Arun District Council
Arun Civic Centre
Maltravers Road
Littlehampton
West Sussex BN17 5LF
Planning & Building Control General Enquiries
Tel: (01903) 737756 Fax: (01903) 730442
Dx: 57406 Littlehampton
Minicom: 01903 732765
e-mail: planning@arun.gov.uk
website: www.arun.gov.uk/planning

Application No: BN/150/20/PL
Site Address: Land at Chantry Mead & Rear of 14 -18 Downview Road Barnham PO22 0EG
Description of works: 3 No dwellings including access, landscaping & associated works (resubmission following BN/51/20/PL). This site is in CIL Zone 2 and is CIL Liable as new dwellings.

Thank you for your internet representation made on 26th June 2021 which has been recorded as an objection with the comments as follows:

PLOT 3 ELEVATIONS
SCALE 1:100 @ a3

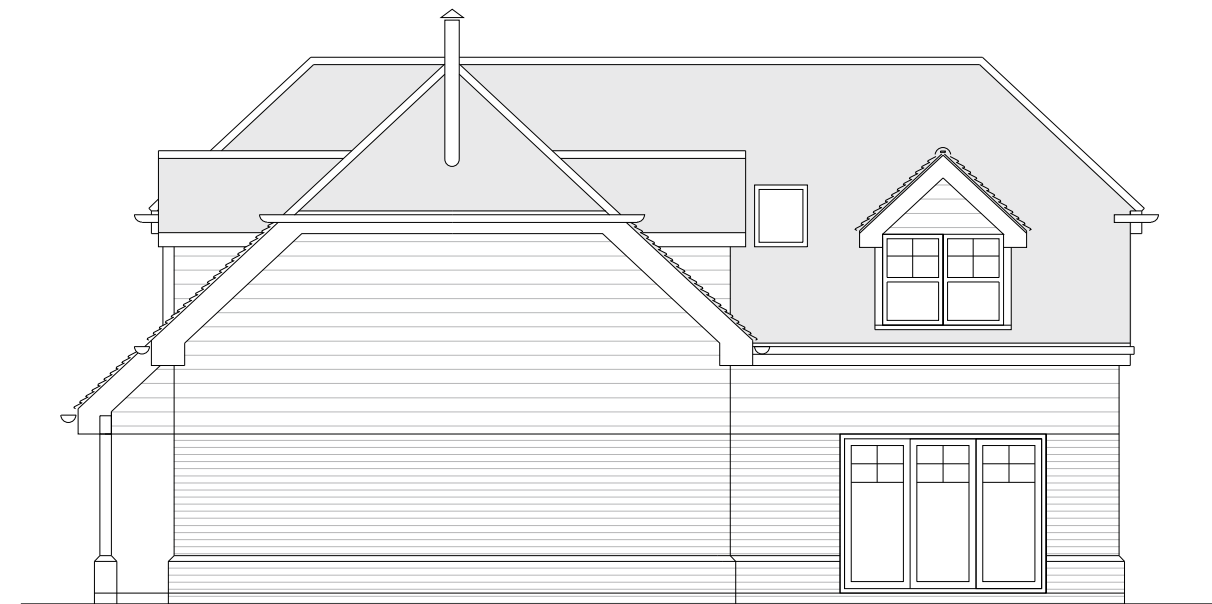
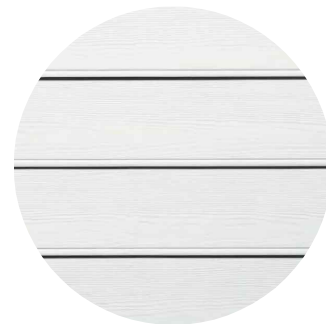
I will enter my objections as I have done on two previous occasions, I note that on the new resubmitted plans the detached 4 bed property may be slightly reduced in overall footprint and that some of the Velux roof windows have been abandoned. However the fact remains that the property is still aligned out of kilter with the house and bungalows on either side.
